DEVELOPMENT REVIEW BOARD
UTILITY DEVELOPMENT
Standard Comment Sheet

DRB-1004814

**Development Review Board 4/19/06 Agenda Item #20
Sketch Plat: Lots 7 & 8, Block B, Eastern Addition**

RE: Lots 7 & 8, Block b, Eastern Addition/sketch

PLAT OF
 LOTS 7-A, 7-B & 8-A, BLOCK B
 EASTERN ADDITION
 PROJECTED SECTION 20, T. 10 N., R. 3 E., N.M.P.M.
 TOWN OF ALBUQUERQUE GRANT
 CITY OF ALBUQUERQUE
 BERNALILLO COUNTY, NEW MEXICO
 MARCH 2006
 SHEET 1 OF 2

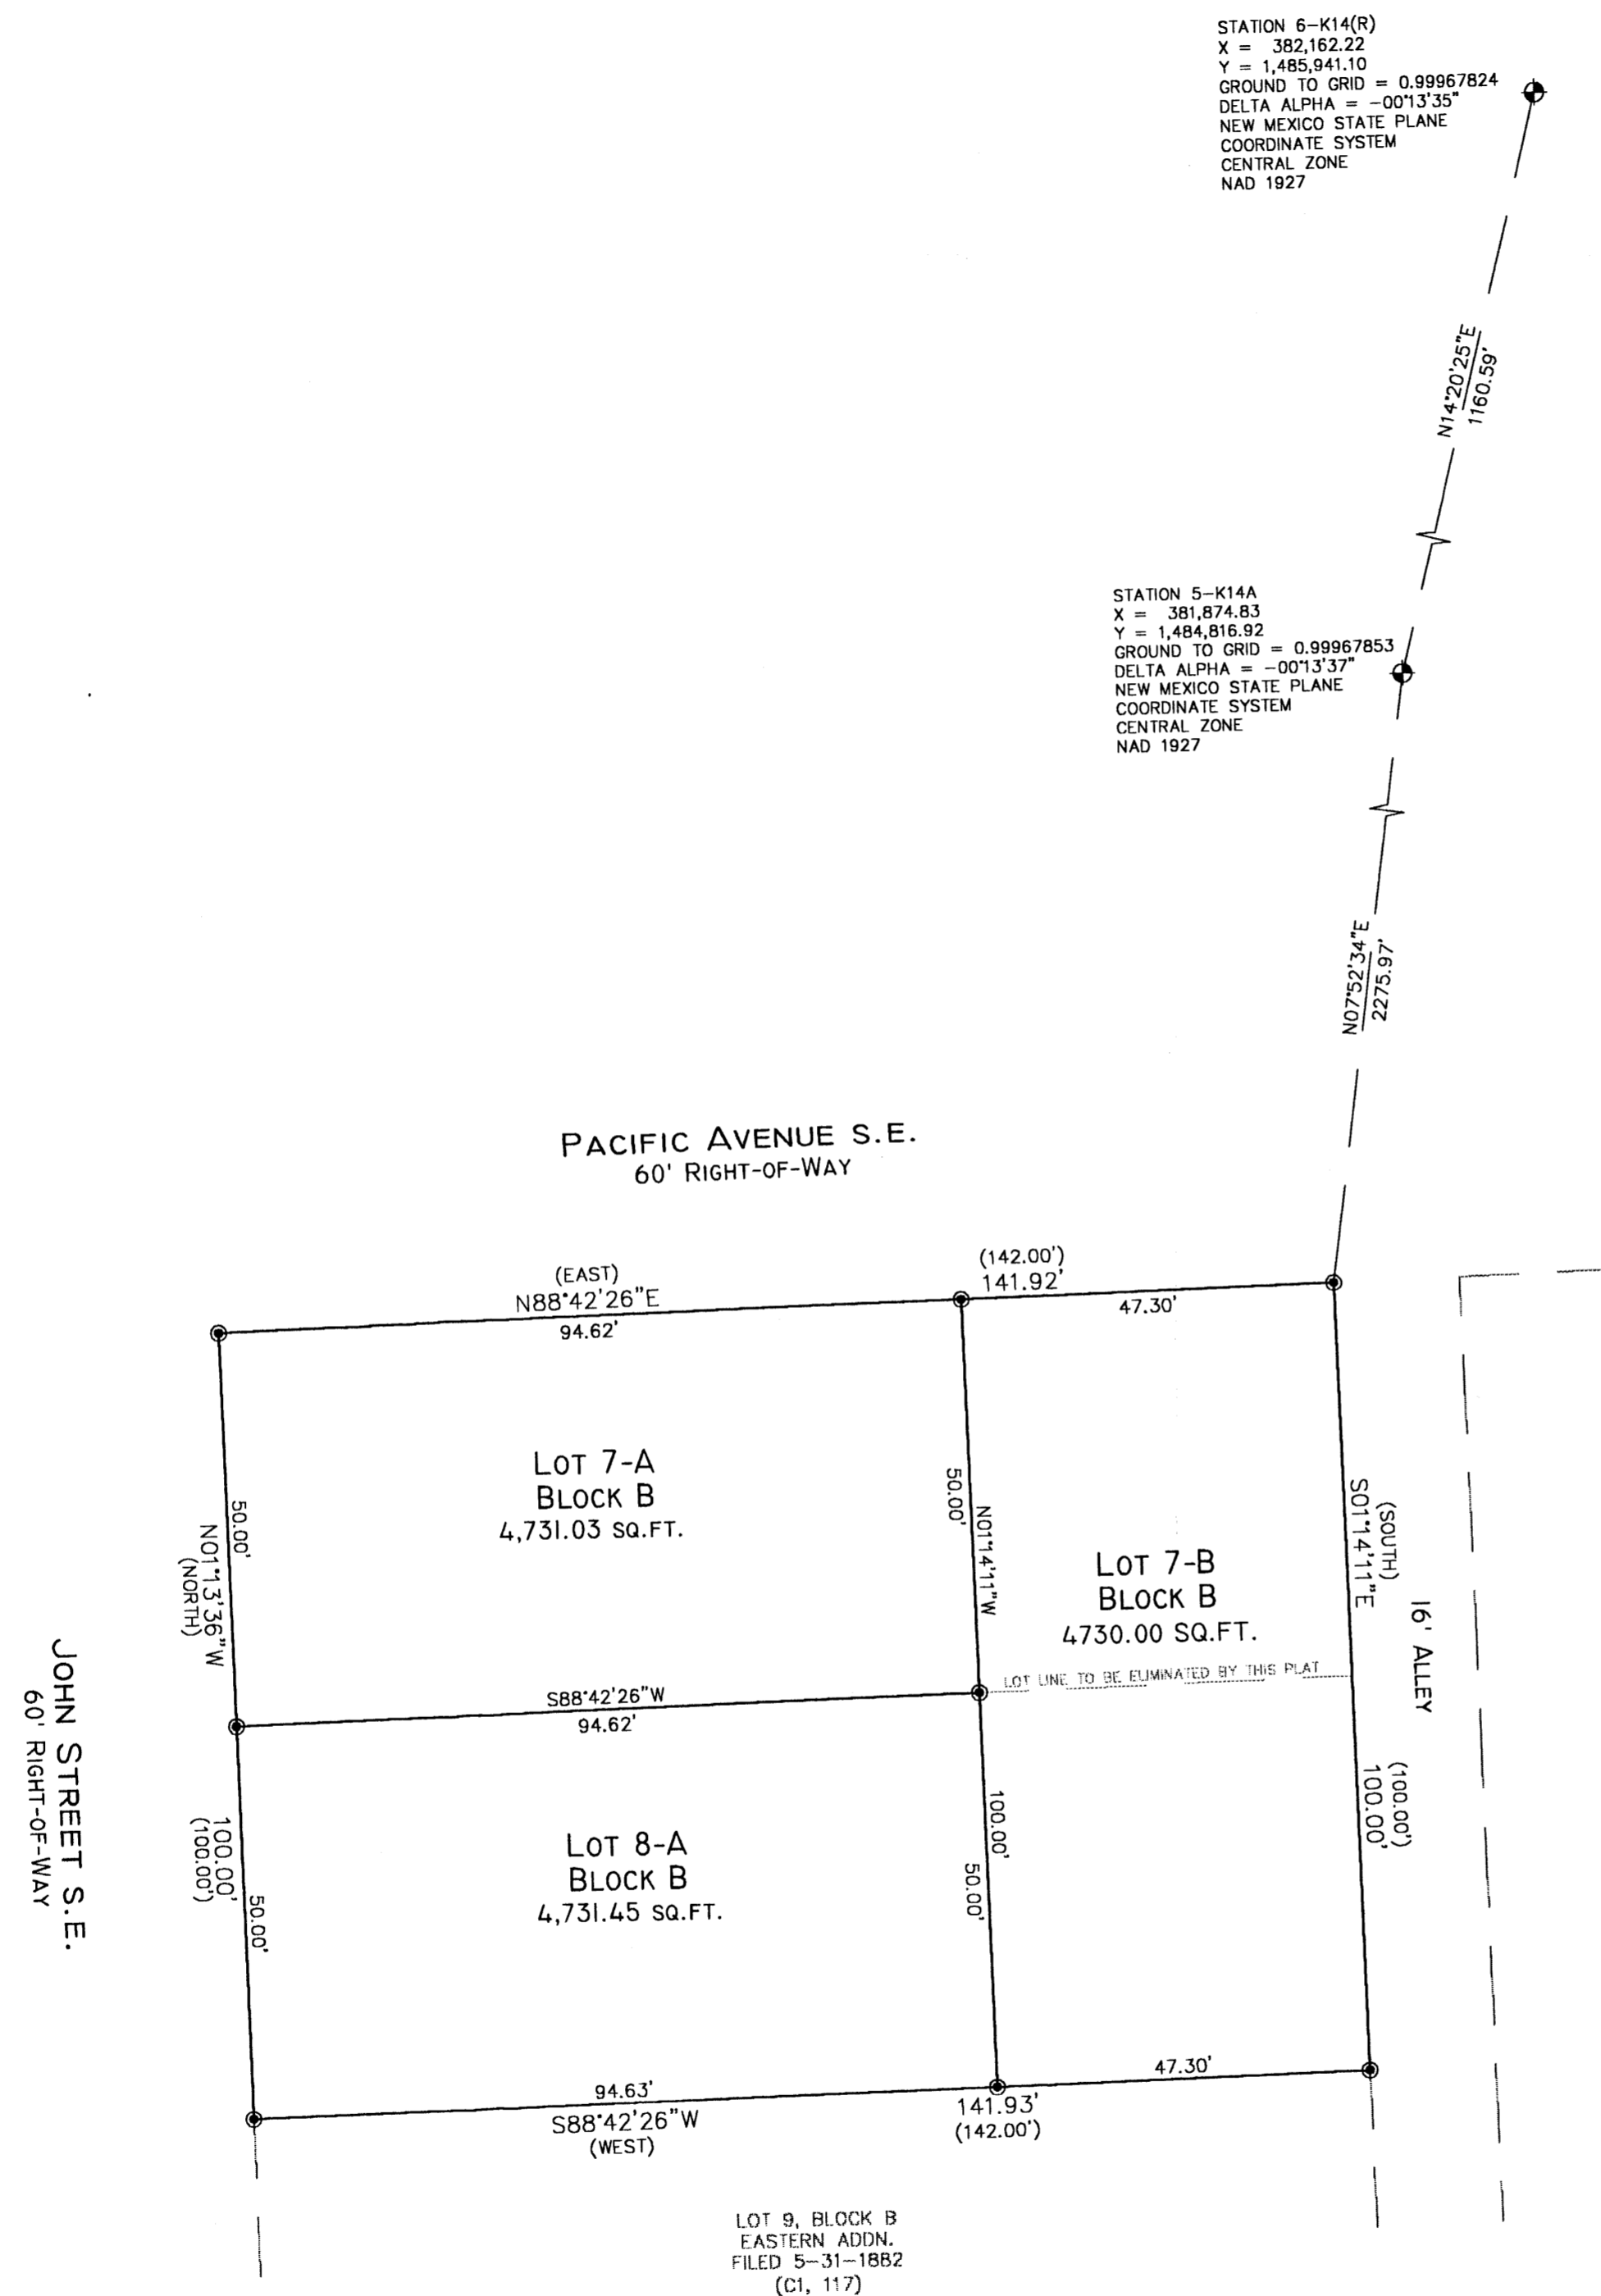
1. Record mapping shows that there are no service lines in Pacific for proposed lot 7-B to connect to. Therefore a private easement must be provide across Lot 8-A for the service lines to connect Lot 7-B to John Street. Water/sewer Tapping permits and a new account for Lot 7-B will be required prior to me signing the Final Plat. There are existing water/sewer accounts for Lots 7-A and 8-A.

This property lies within the South Broadway Neighborhoods Sector Plan boundaries. Minimum lot size for SU2-MR zoning is 5,000 square feet with 50' minimum lot width.

The 3 lots shown do not meet this criteria.

The setbacks are as required in the R1 zone.
